Final WSCC Highways comments

WEST SUSSEX COUNTY COUNCIL CONSULTATION

TO:	Arun District Council - FAO: Simon Davis
FROM:	WSCC - Highways Authority
DATE:	11 January 2022
LOCATION:	Land at Bayards Level Mare Lane Eastergate PO203RZ
SUBJECT:	AL/113/21/OUT Outline application with all matters reserved, apart from access, for up to 69 No dwellings with access, parking, landscaping & associated works. This application is a Departure from the Development Plan. Revised Stage 1/2 Road Safety Audit and Appendices.
RECOMMENDATION:	No Objection

SECONDARY DIRECTION VISIBILITY SPLAYS

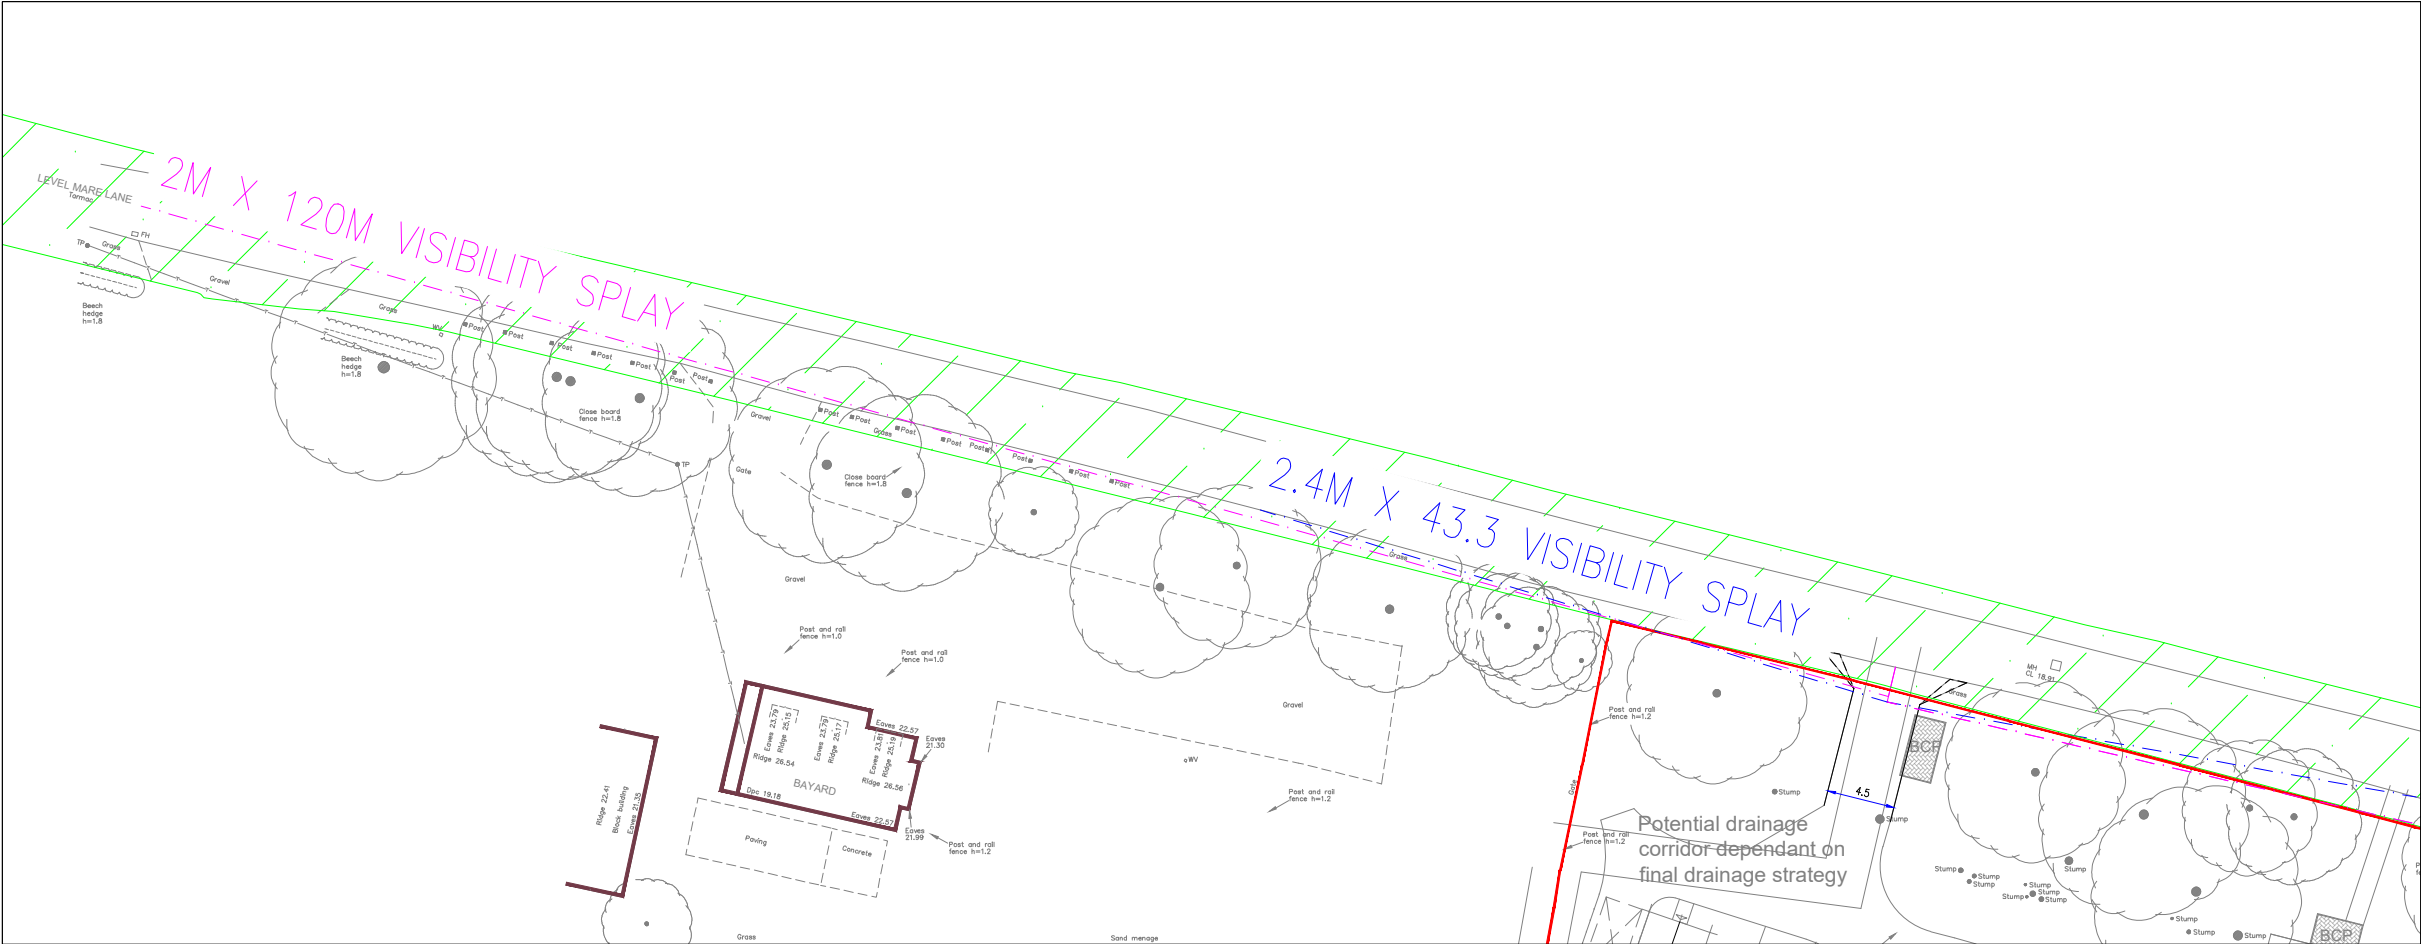
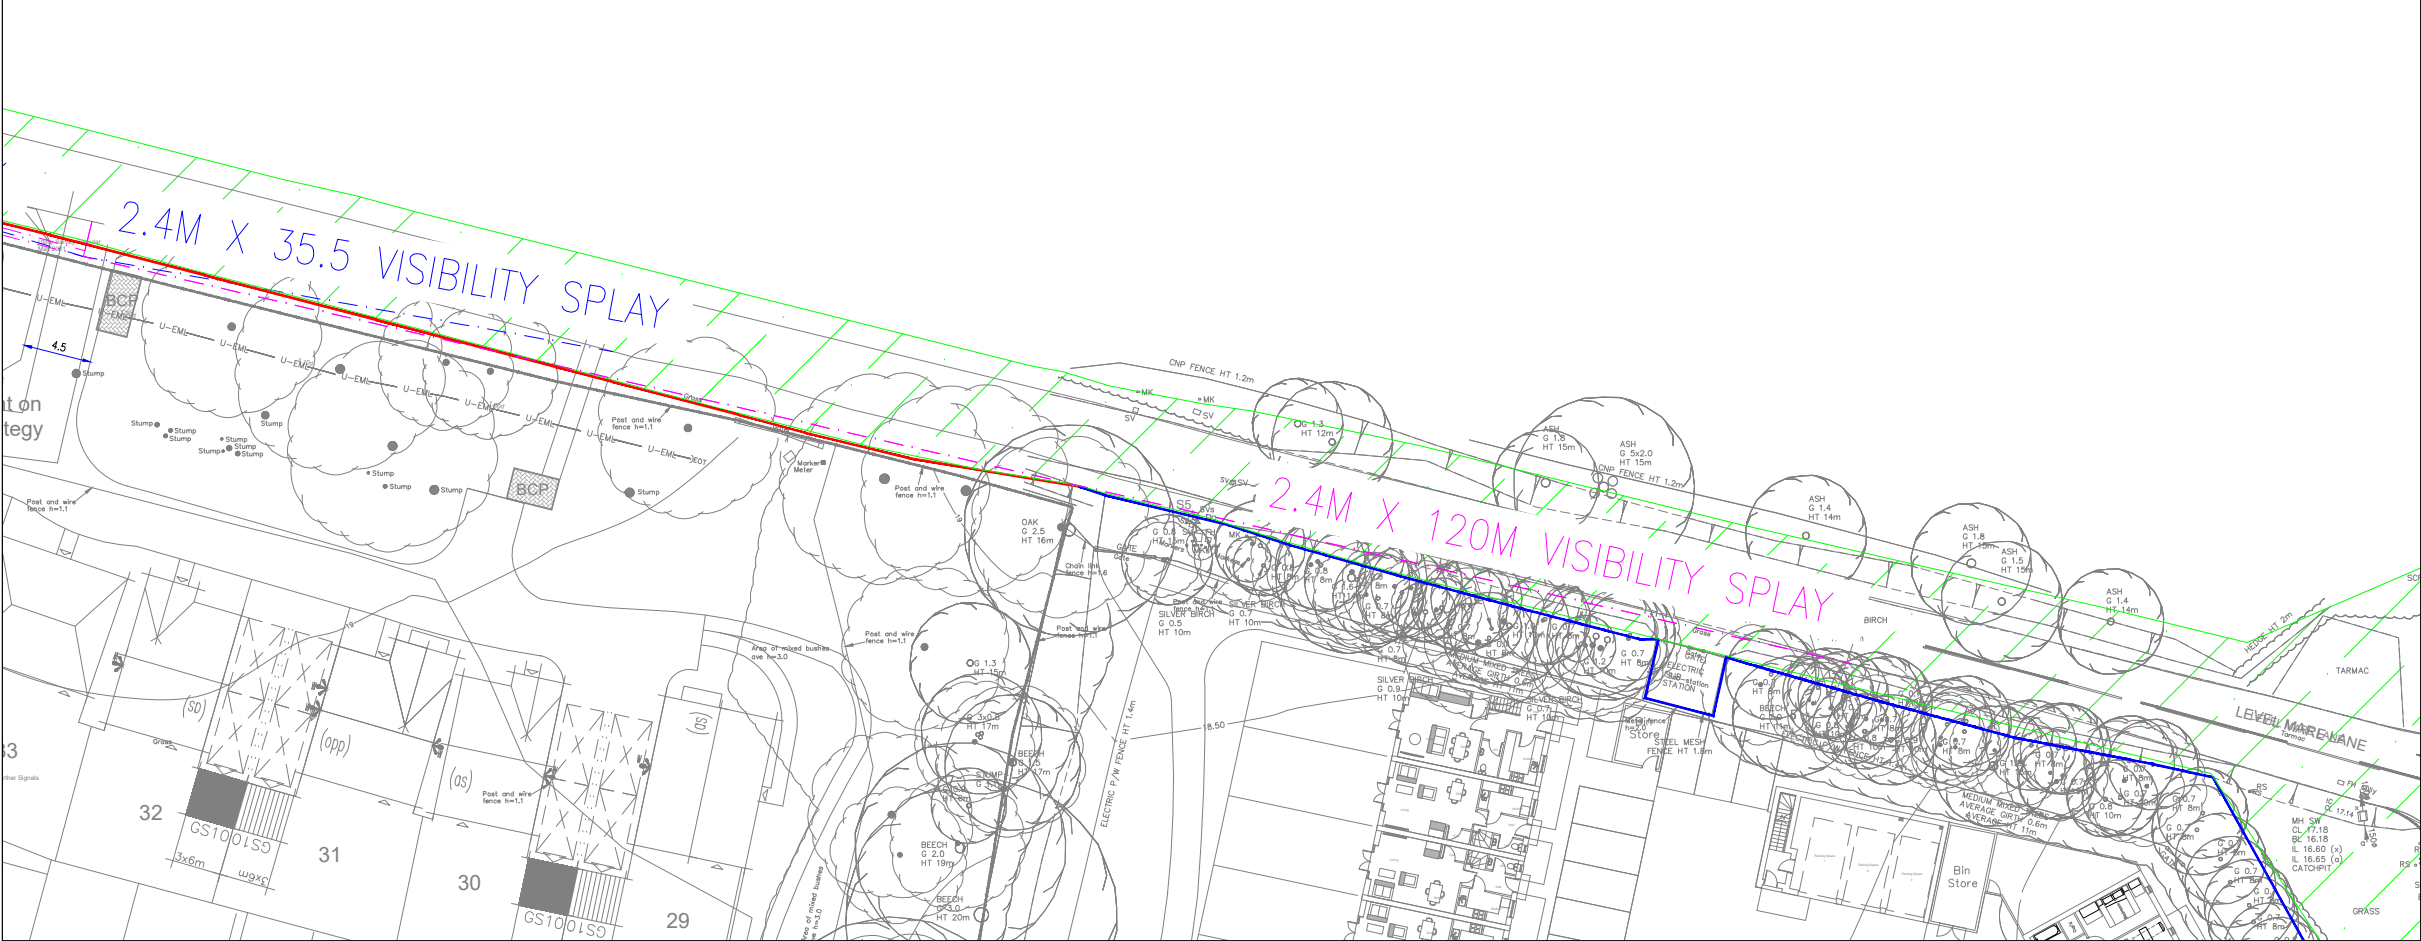
No part of the development shall be first occupied until such time as the vehicular access from Level Mare Lane serving plots 29-34 has been constructed in accordance with the details shown on the drawing titled LEVEL MARE LANE VISIBILITY SPLAYS and numbered 020.0672.007 Rev. A.

No part of the development shall be first occupied until visibility splays as detailed on drawing titled LEVEL MARE LANE VISIBILITY SPLAYS and numbered 020.0672.007 Rev. A. have been provided at the proposed site vehicular access onto Level Mare Lane in accordance with the approved planning drawings. Once provided the splays shall thereafter be maintained and kept free of all obstructions over a height of 0.6 metre above adjoining carriageway level or as otherwise agreed.
